FAO Case Officer
Planning
Objection re 2020/92284

The application:

PROPOSED SITEPLAN 1:250 @ A2

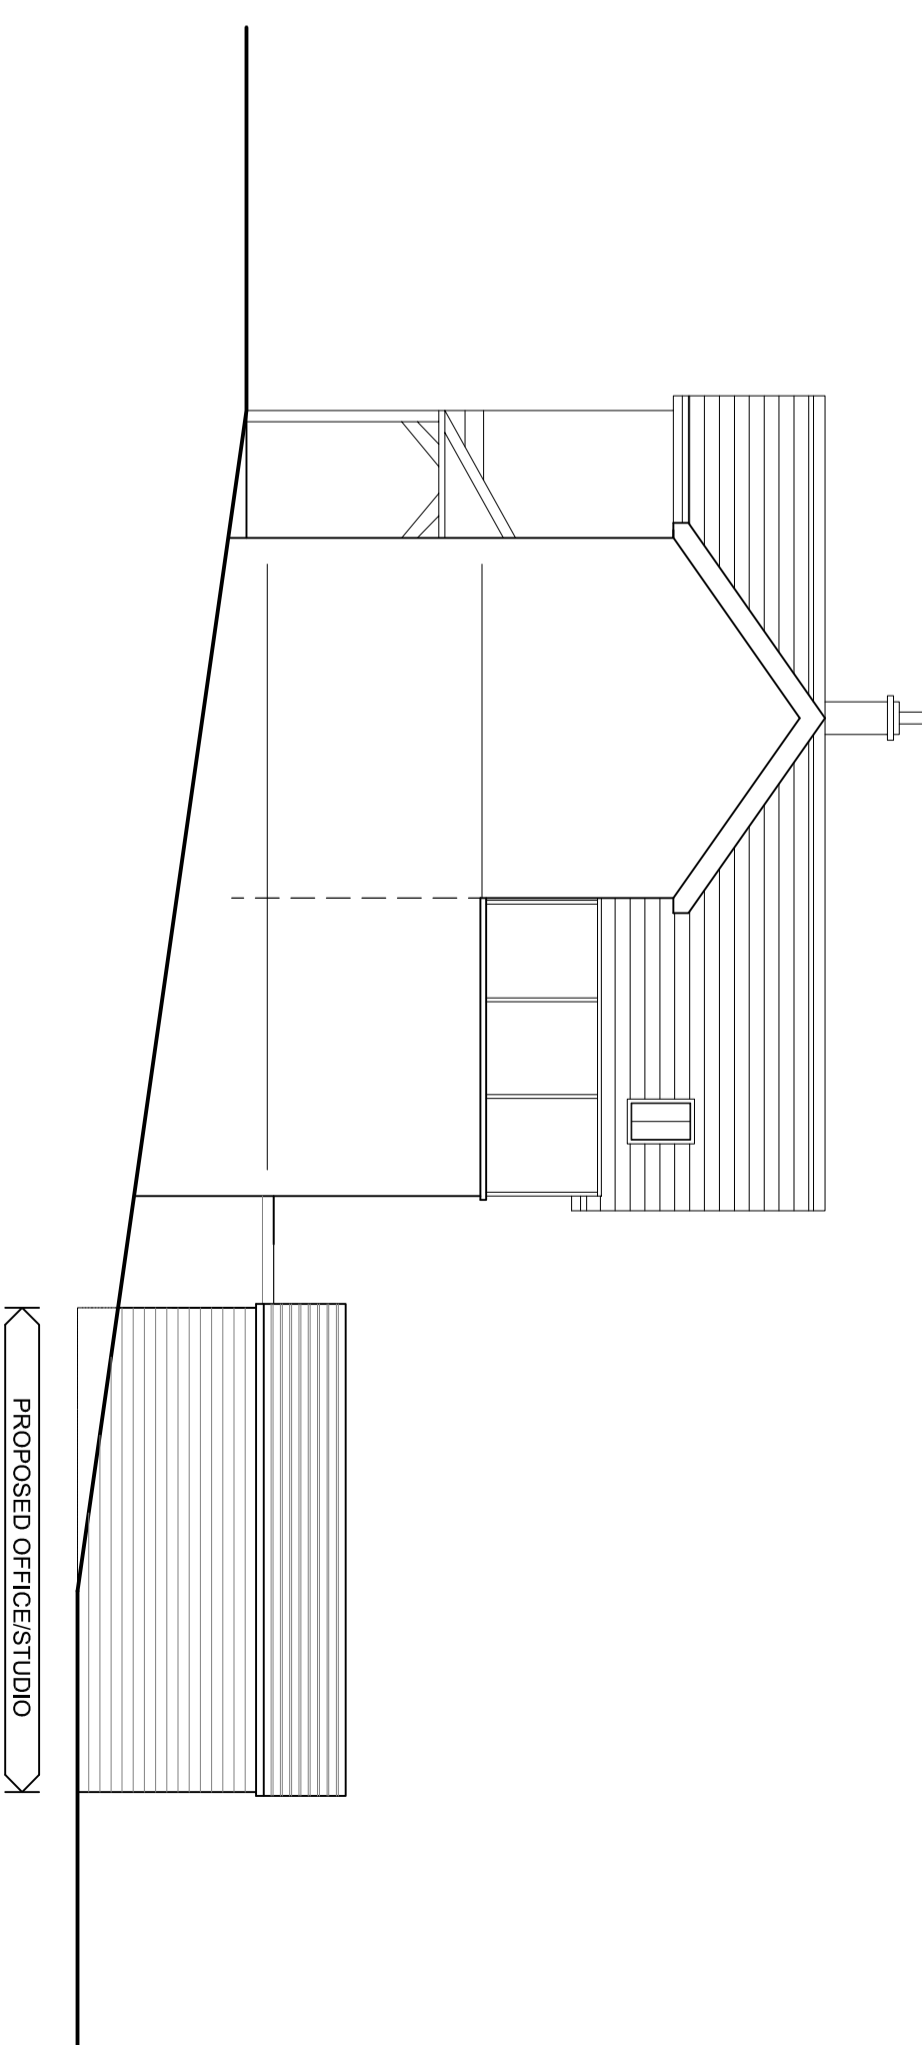
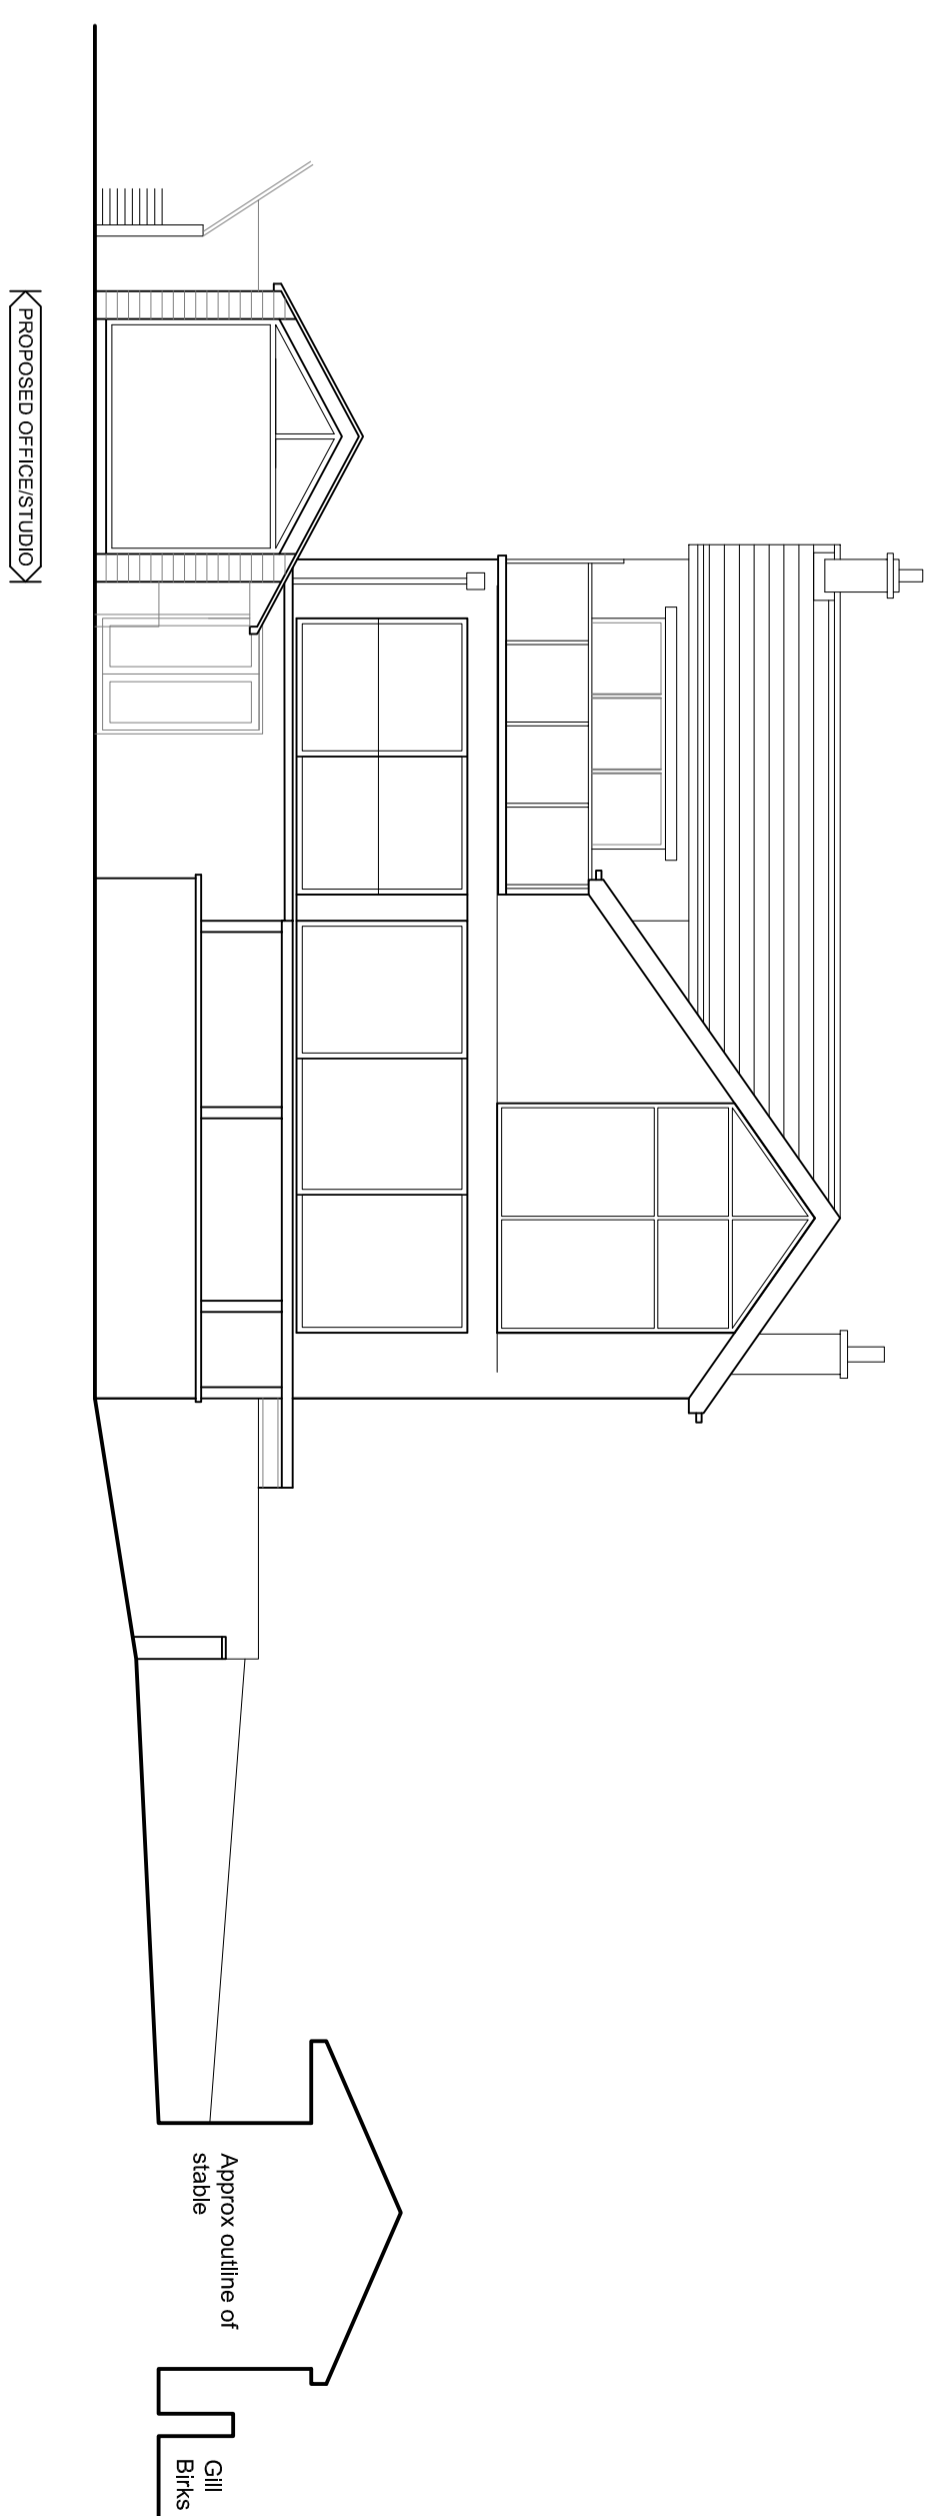
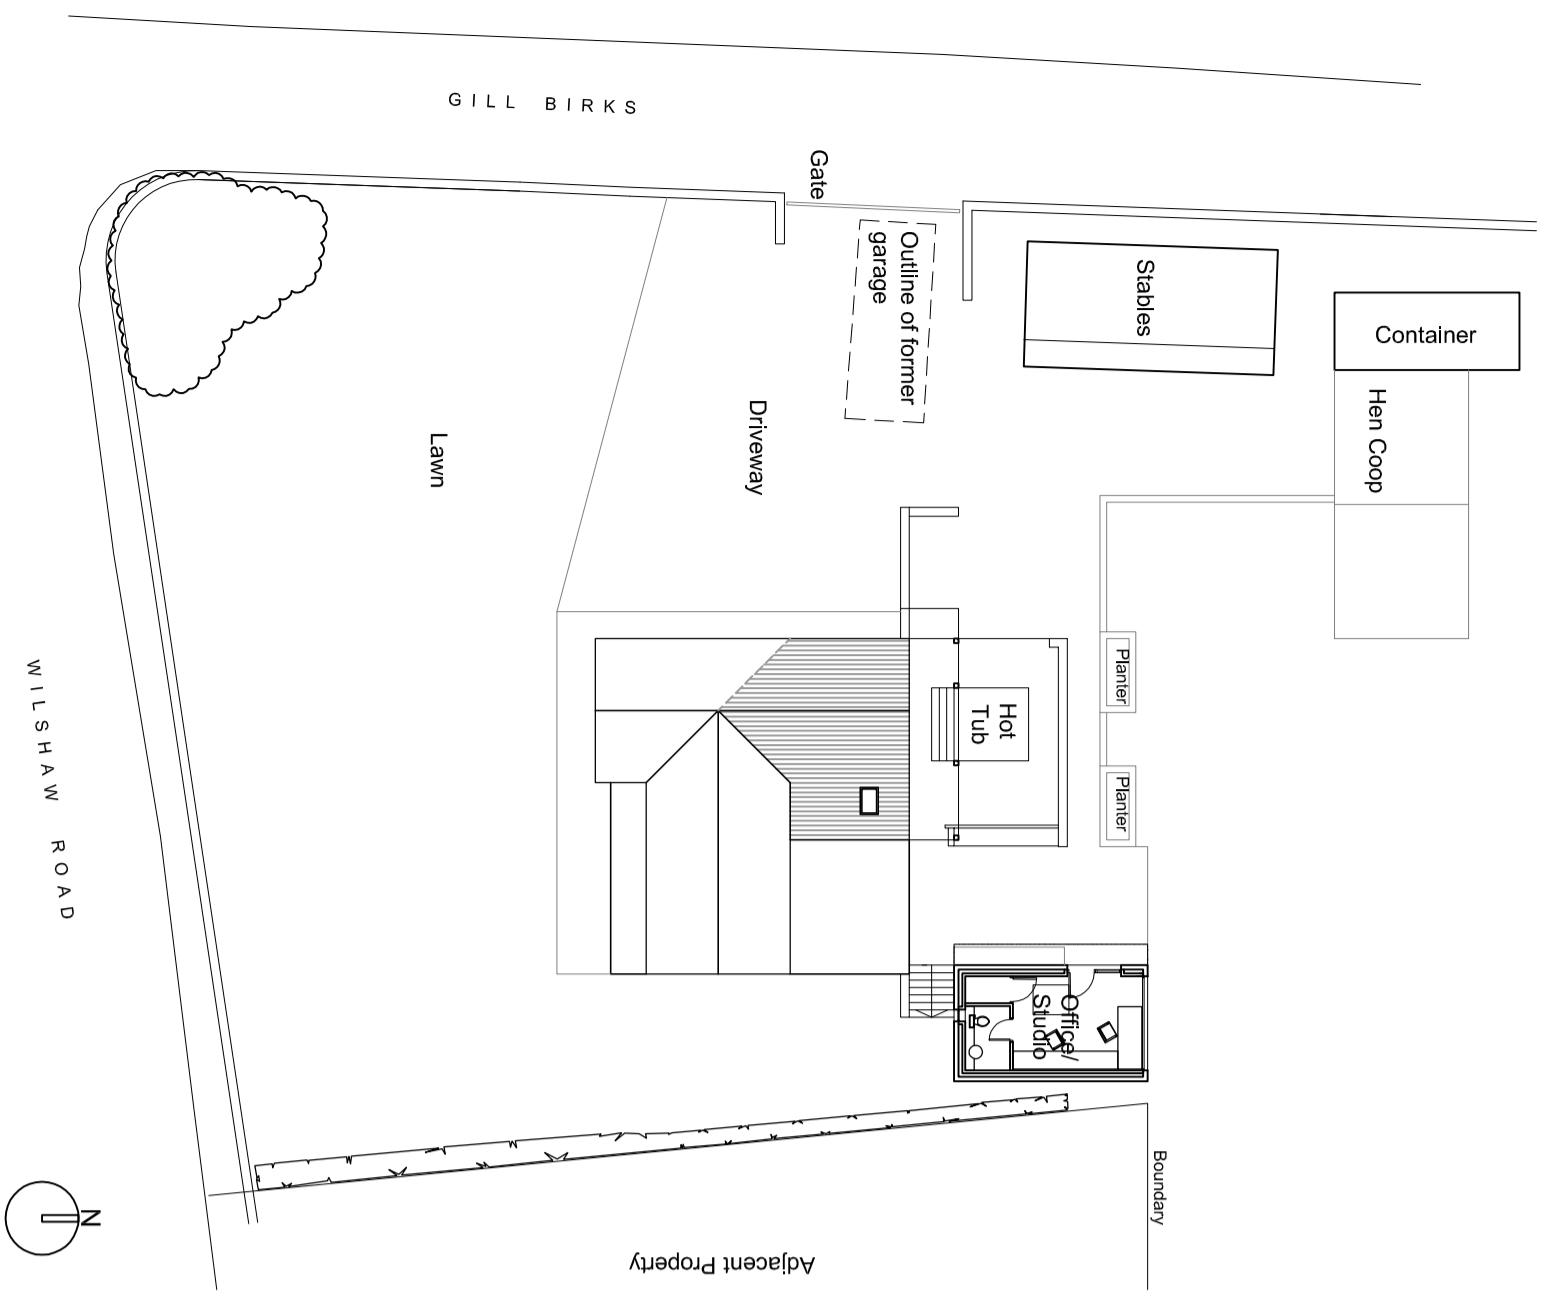
- form, scale, layout and/or details in all development respects,
- enhancing the character of the townscape, heritage assets and landscape.
- amenity for future and neighbouring occupiers. Specifically, the proposal requires significant changes in level with no indication on the impact of the existing or neighbouring properties regarding stability or drainage proposals.
- being in keeping with the existing buildings in terms of scale, materials and details not least because the building, to which it is being compared, is not approved.
- disabled people, older people and families with small children by the creation of accessible and inclusive places. Without question the plans include new outdoor steps. The extent of the problem cannot be determined by the drawings as there is no consistency between the plans on the number of steps or the height of finished landscaping
